**Consultation Response from KC,  
Highways Development Management****2024/92809 Popeley Farm, Muffit Lane, Gomersal, Cleckheaton, BD19 4QS****Prior notification for change of use from agricultural building to 1 dwelling****Date Responded: 13/11/2024.****Responding Officer: D. Stainsby****Responding Ref: K9-12NE/4****RECOMMENDATION:**

## Unit B (B8) site plan as proposed

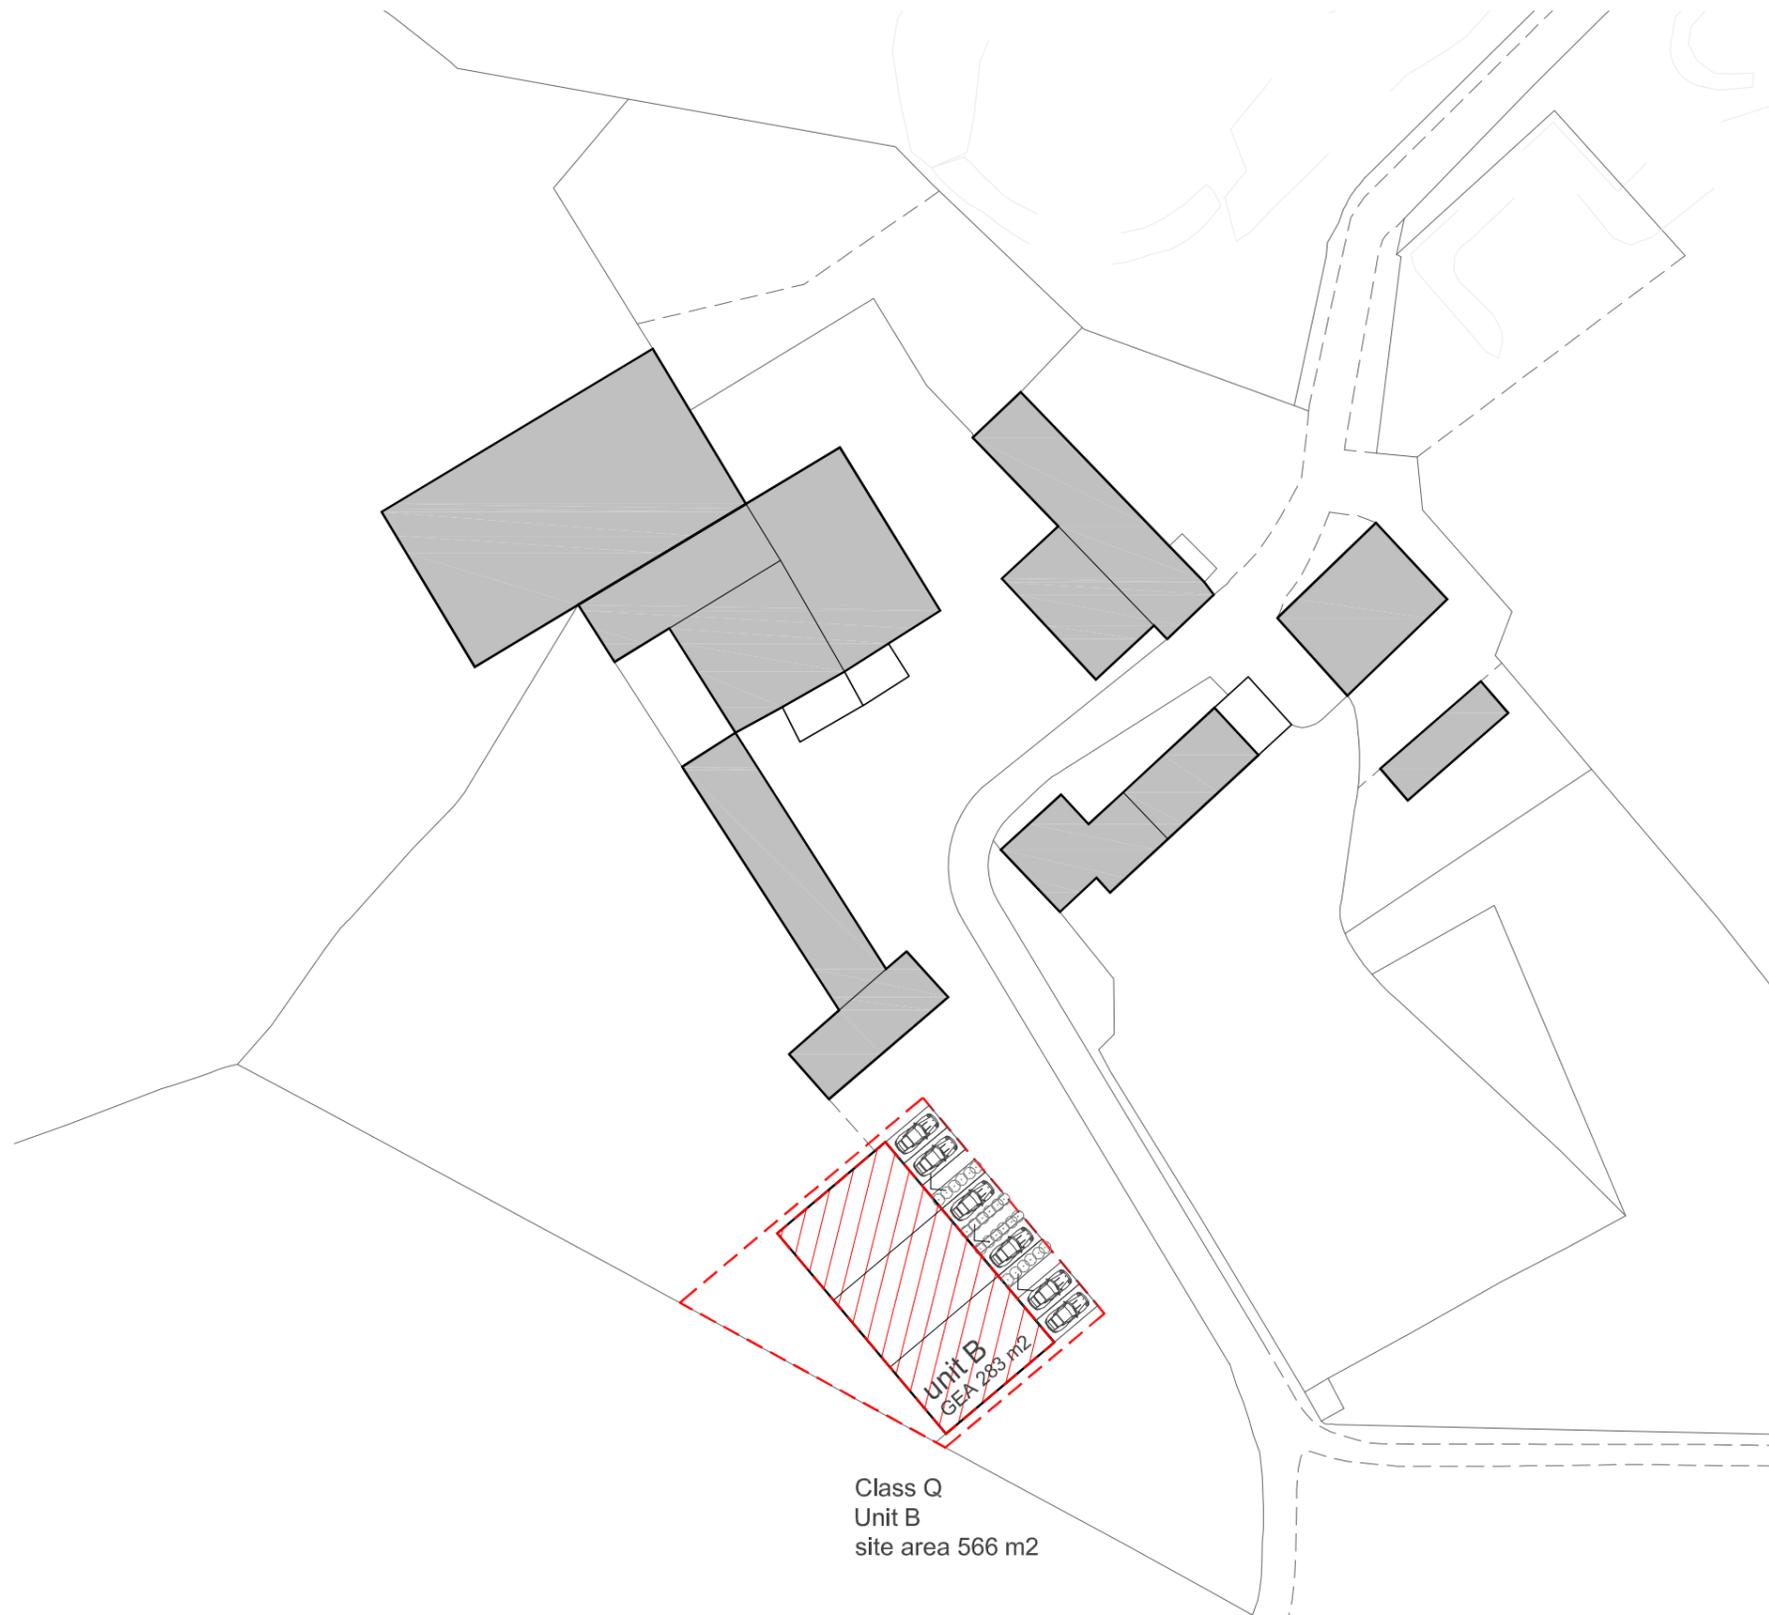
The driveway to the proposed dwelling is longer than 20m and the emergency access requirements require that the minimum width of the driveway would need to be 3.7m for its full length.

A turning area for fire tenders is also required when the route is longer than 20m.

A swept path analysis to show that a Kirklees fire service vehicle can both access and turn within the site in the case of an emergency needs to be provided.

The bin stores are over the minimum carry distance for the refuse collectors and as such a bin collection/presentation point should be located adjacent to the public highway.

Details of the waste collection for the proposed dwelling should be provided, with the location of a waste collection presentation point being clearly marked on a drawing in such a location that is easily accessible to the collection team and where it will not obstruct the access or the adopted highway for road safety reasons.

EXISTING VISIBILITY SPLAYS

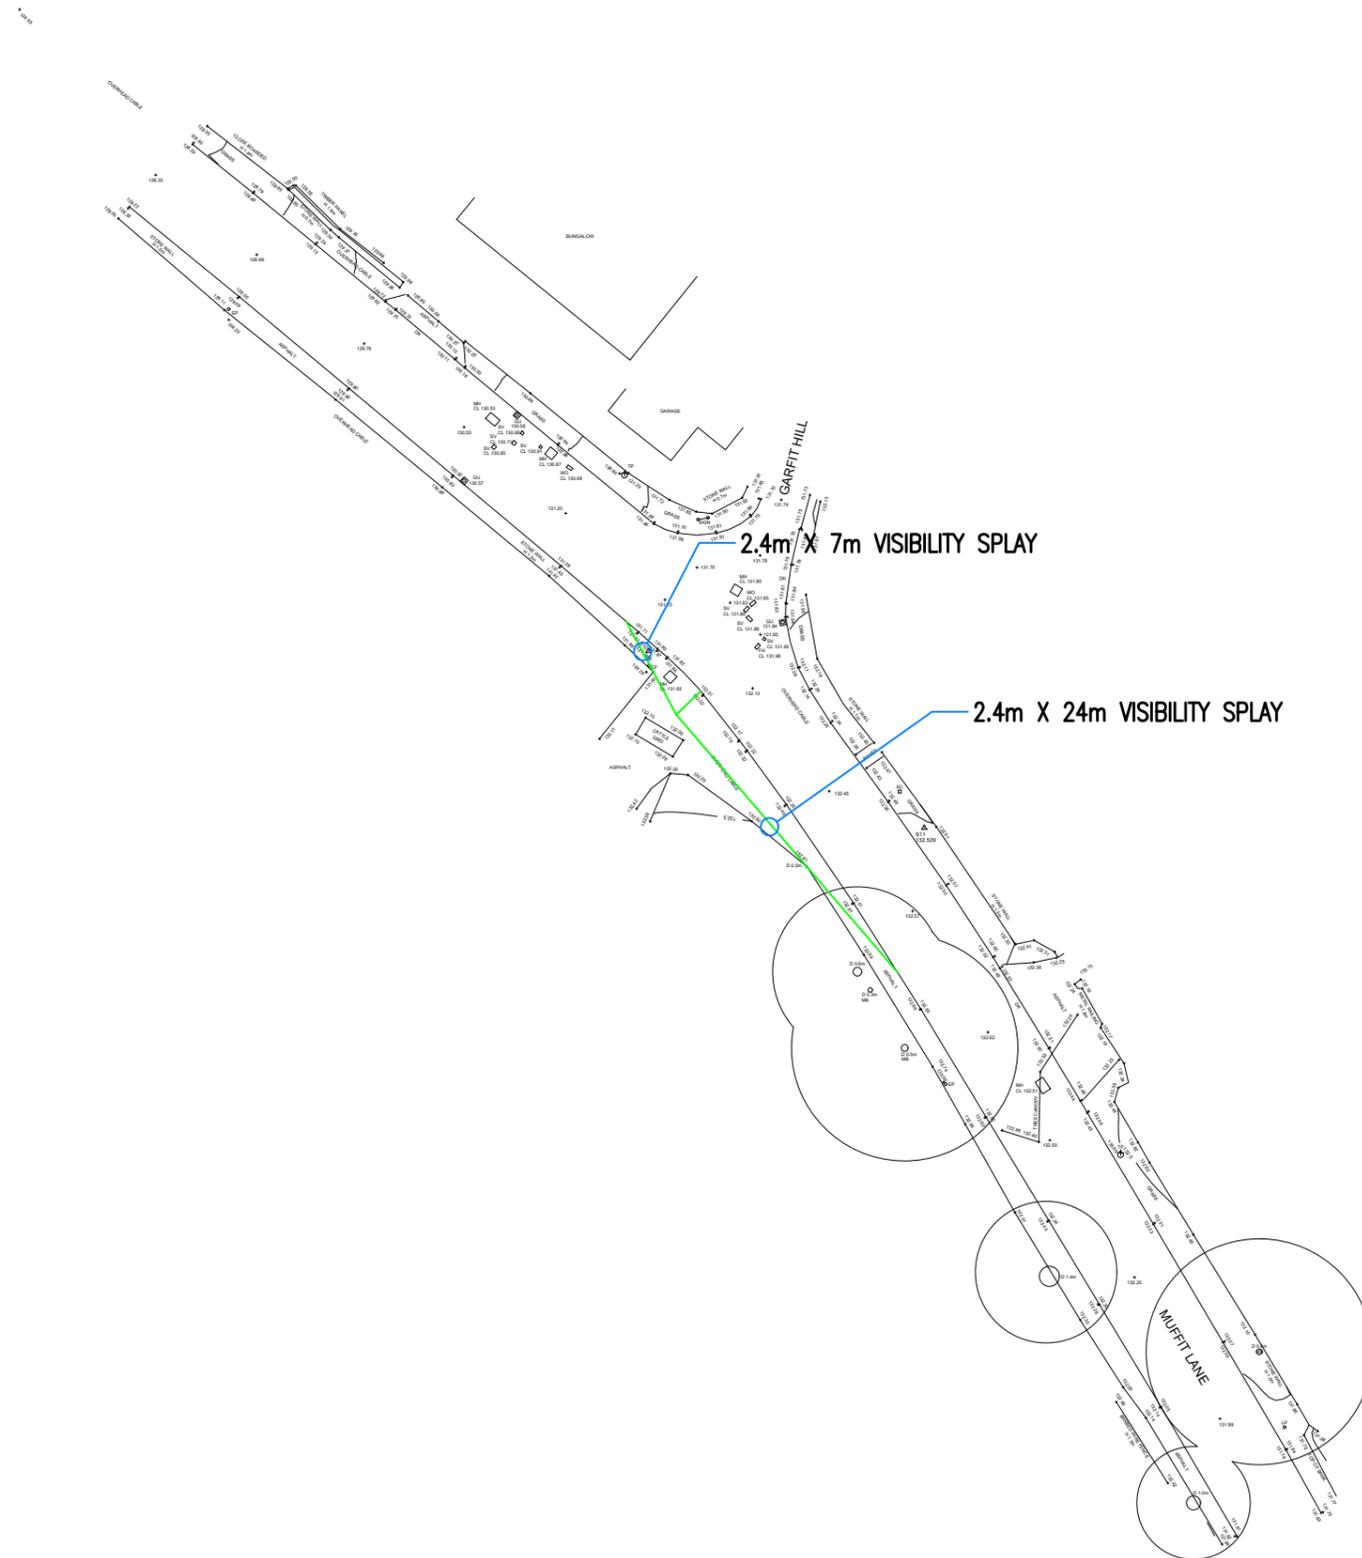
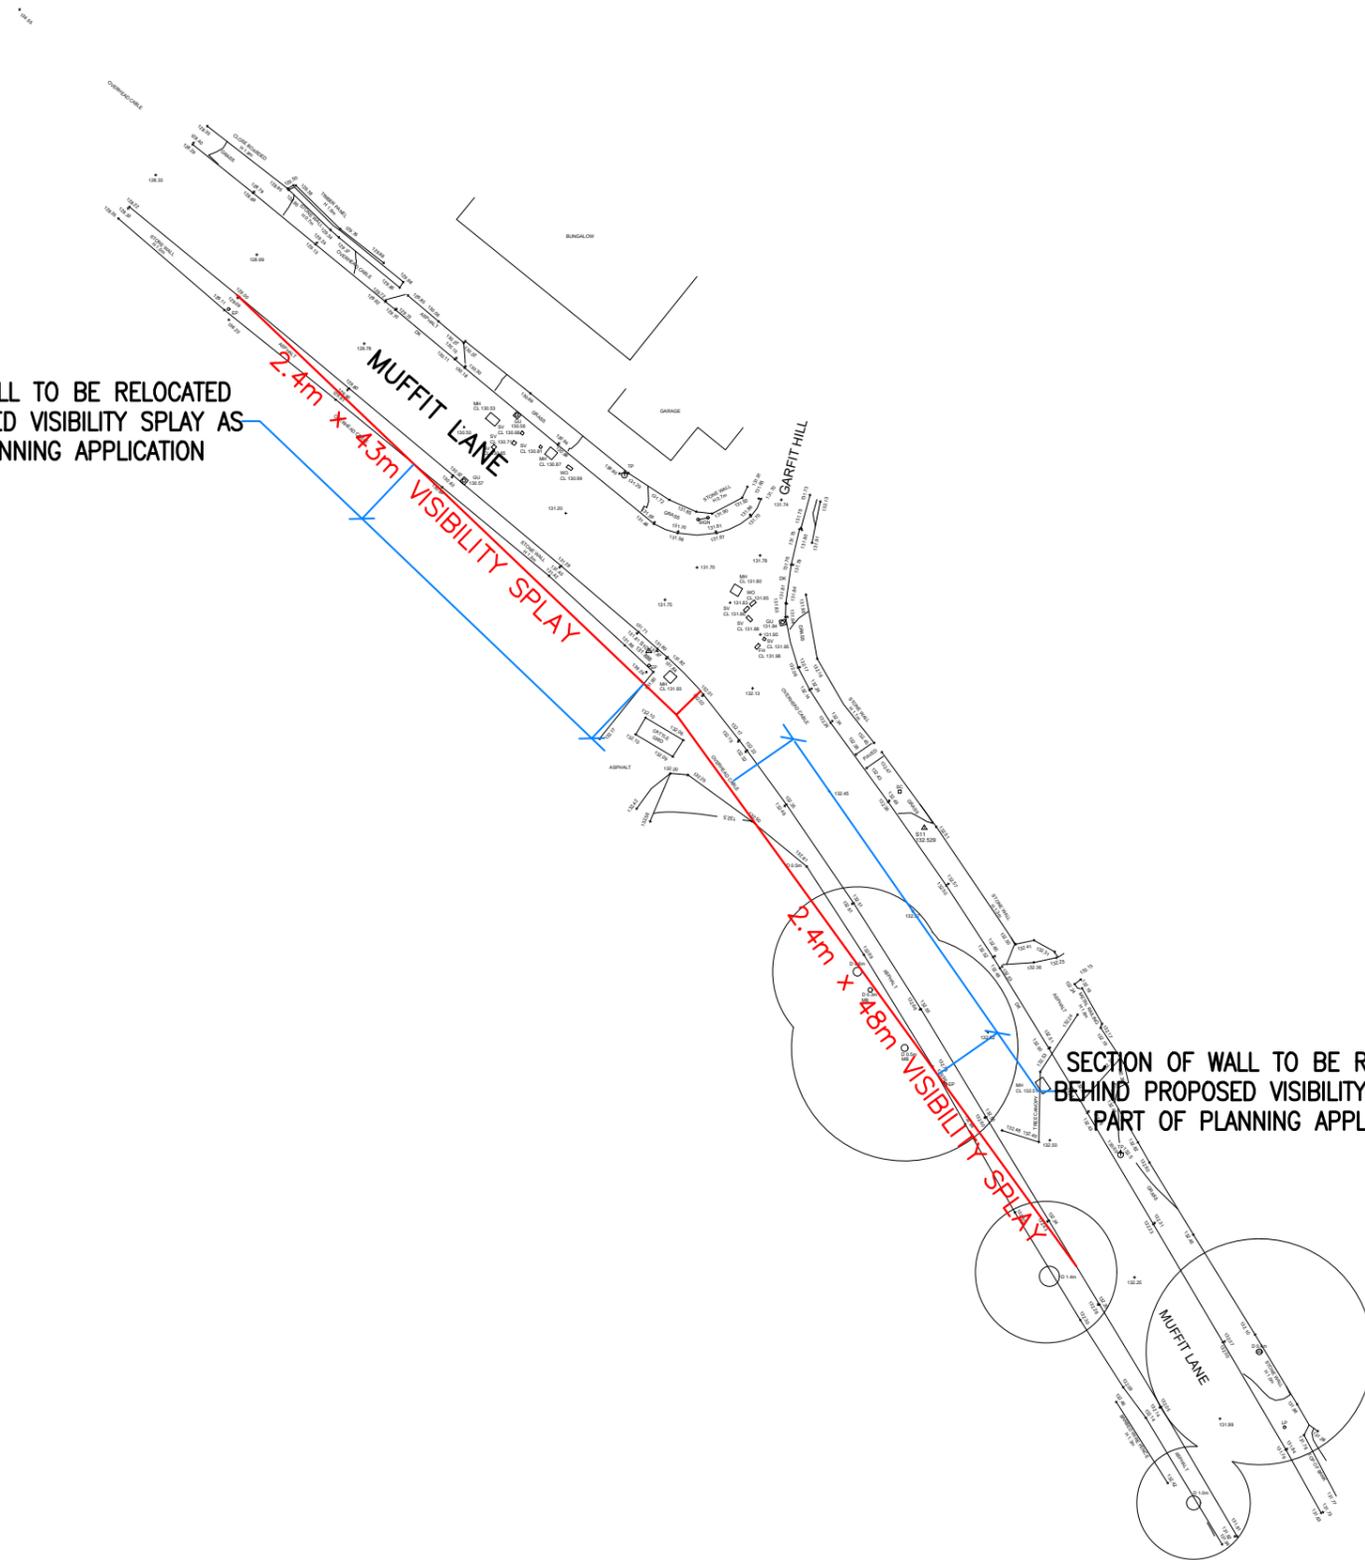
The existing visibility splays are substandard and will need improving. However, the Applicant has now submitted a drawing showing that the recommended visibility splays can be met at this access. These will need to be conditioned for the lifetime of the development.
